**Planning Application 6/2021/0079/FULL
8 Hill Rise, Cuffley EN6 4EE**

I write on behalf of Mr C Theodorou, the occupier of the neighbouring property at 6 Hill Rise, to raise objection to the above application seeking planning permission retrospectively for the erection of a dwelling (revisions to planning permission Ref 6/2018/0383/FULL).

Project Address	8 Hill Rise, Potters Bar, EN6 4EE
Sheet Title	As Built Ground and First Floor Plans
Sheet Number	A101
Paper Size	A1
Revision	
Issue Date	01/01/2021

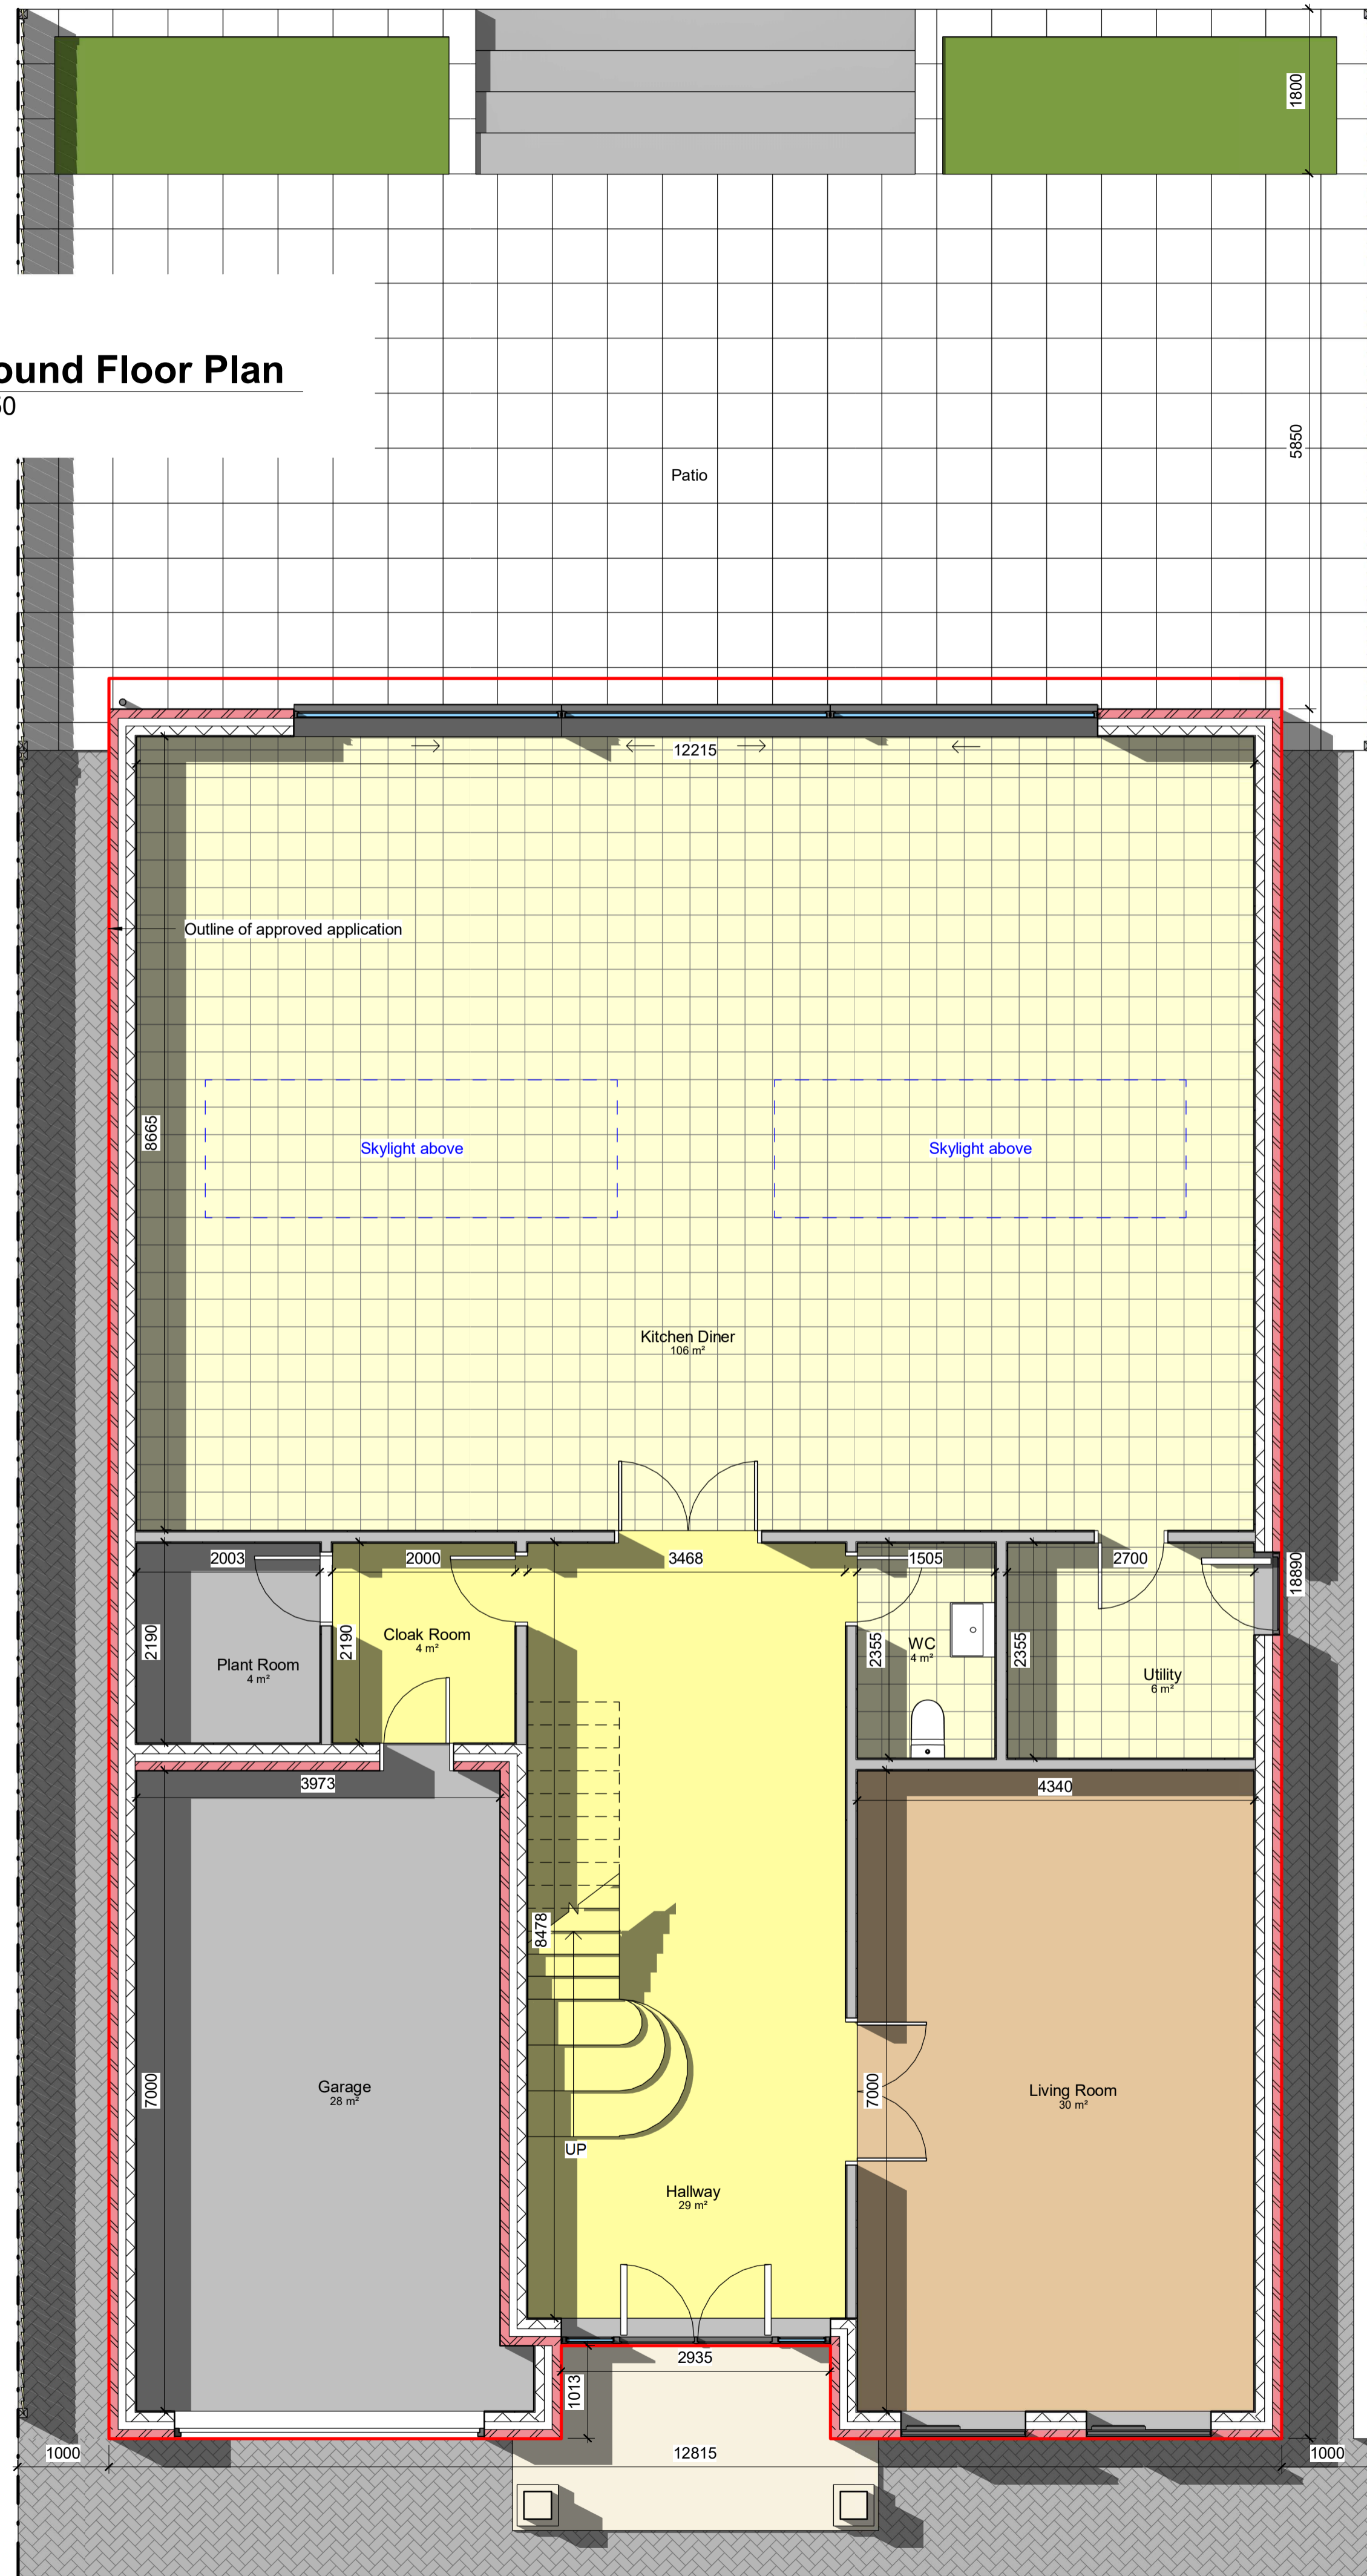
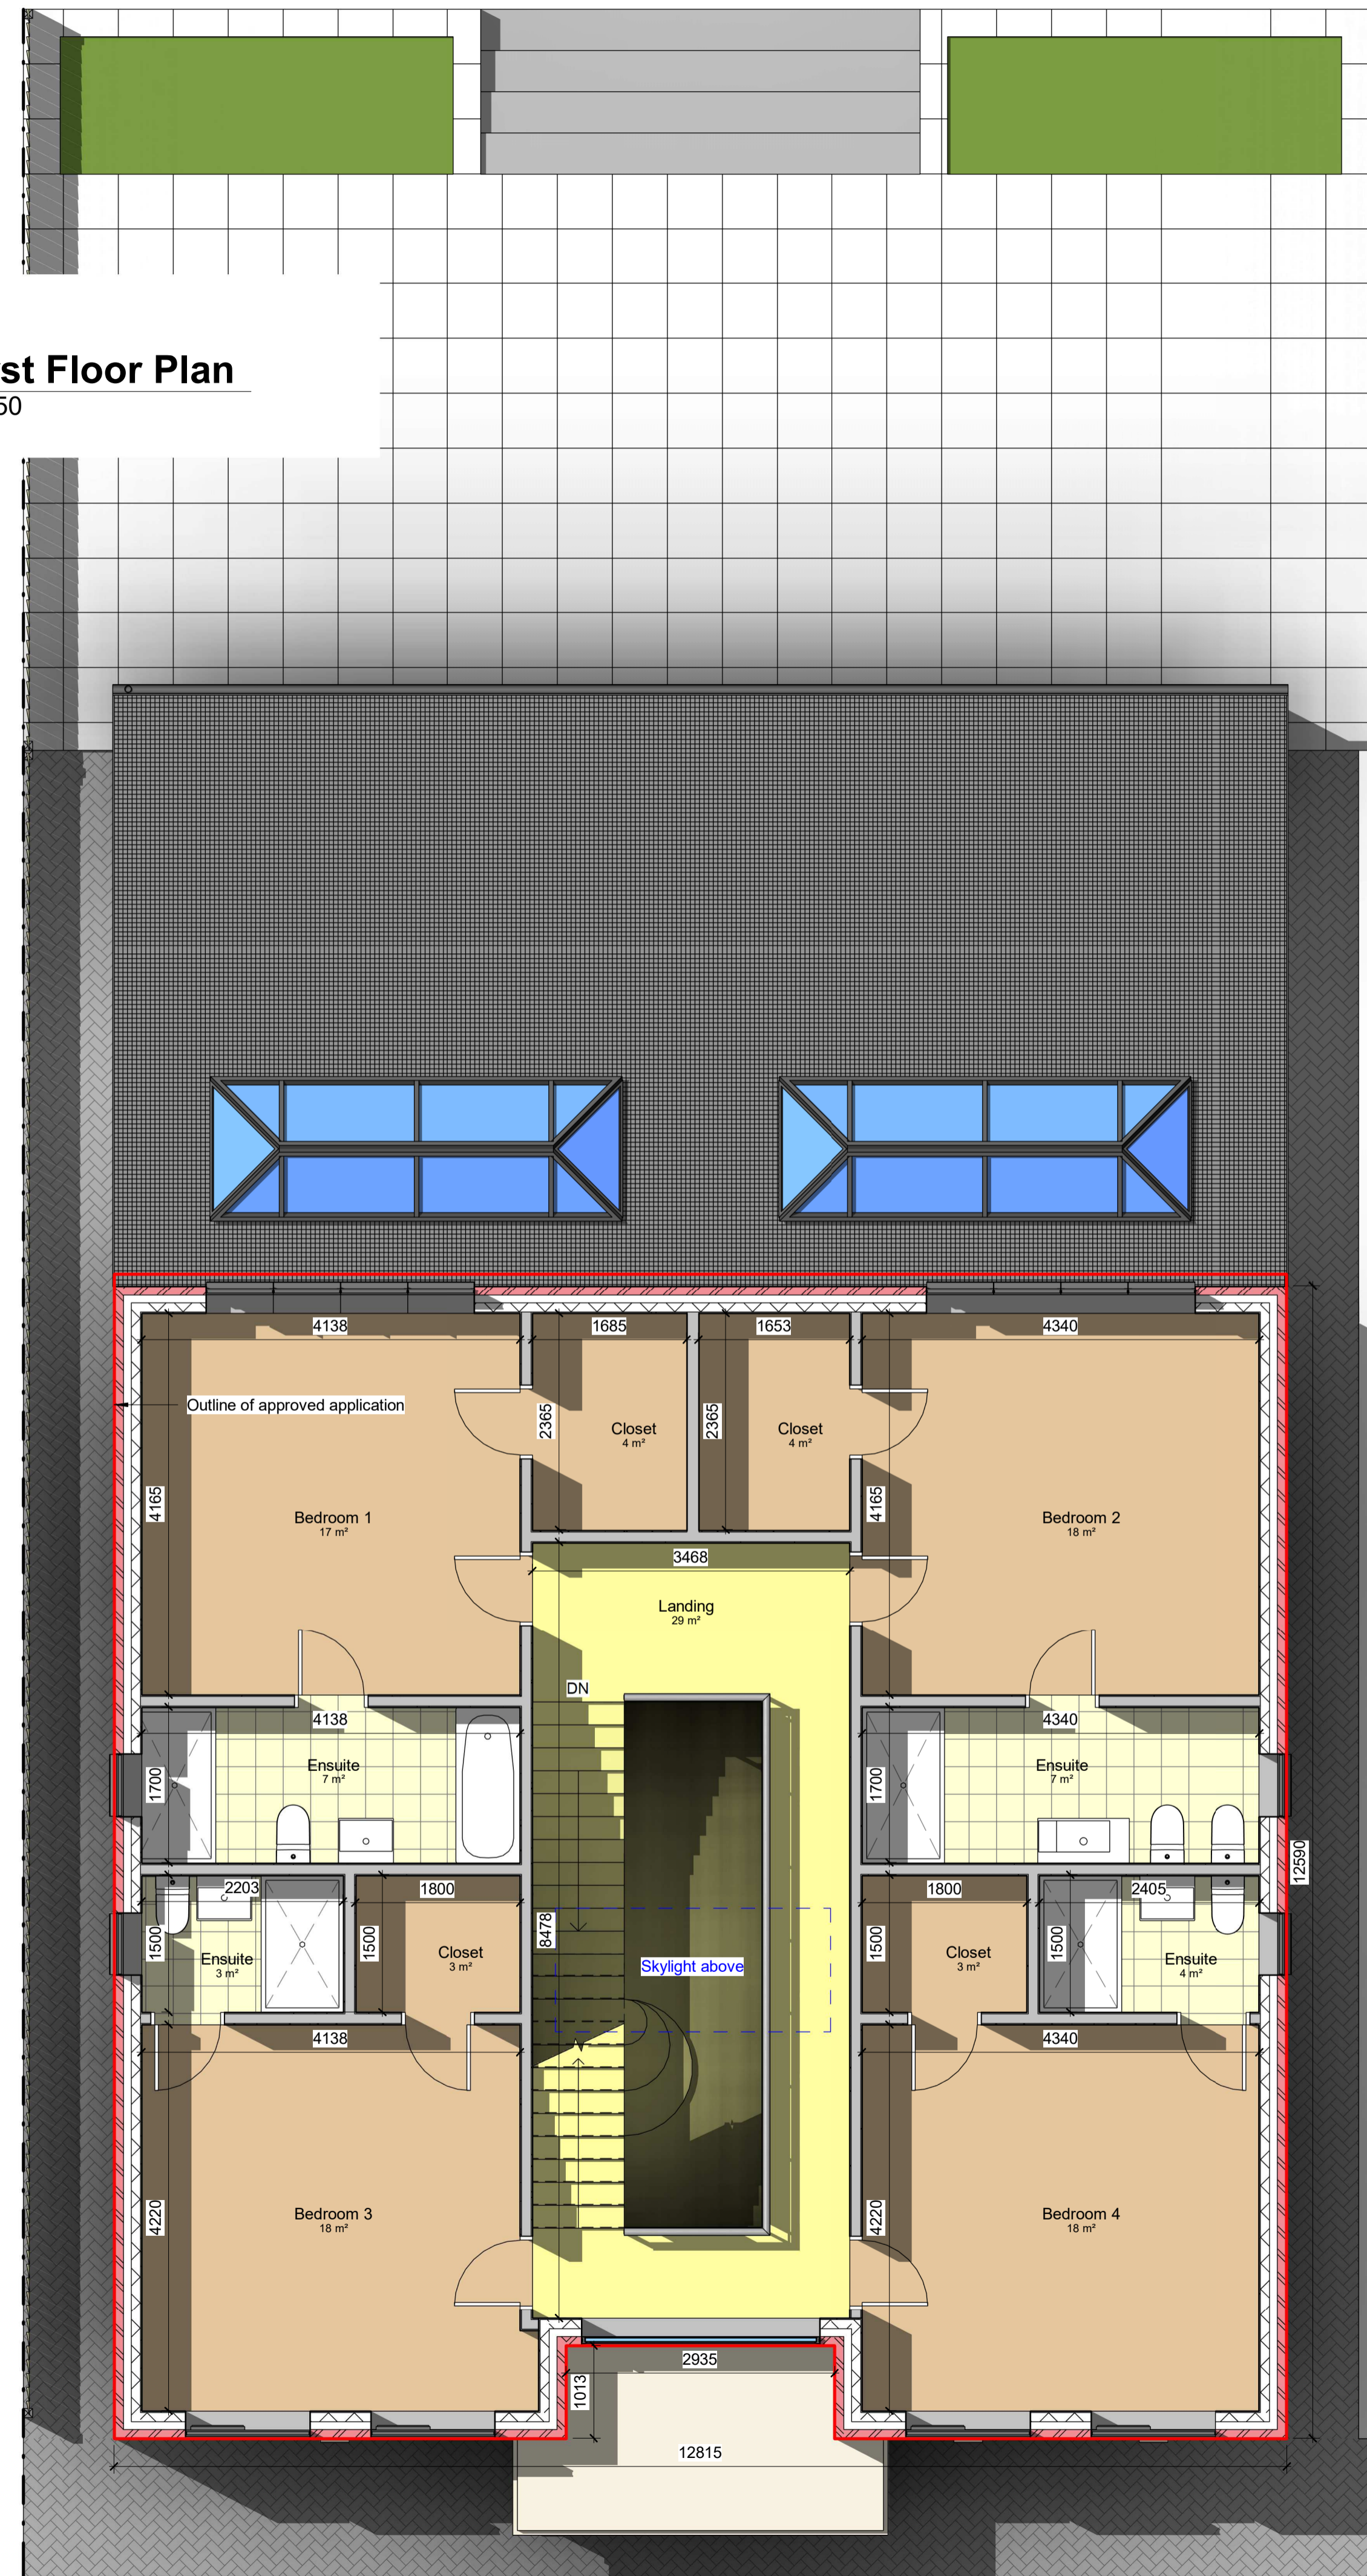
Overall, we consider the raised patio severely restricts neighbouring occupiers' reasonable enjoyment of their rear garden amenity spaces. Further harm is caused to the living conditions at my client's property by the insertion of new window openings, not shown on the approved plans, into the southeast side elevation of the dwelling at 8 Hill Rise. The approved plans show only a single obscure glazed window. As a minimum, we would expect all new side window to be obscure glazed and, in our opinion, the original plan showing only a single obscure glazed window should be retained in order to minimise potential overlooking of neighbouring properties.
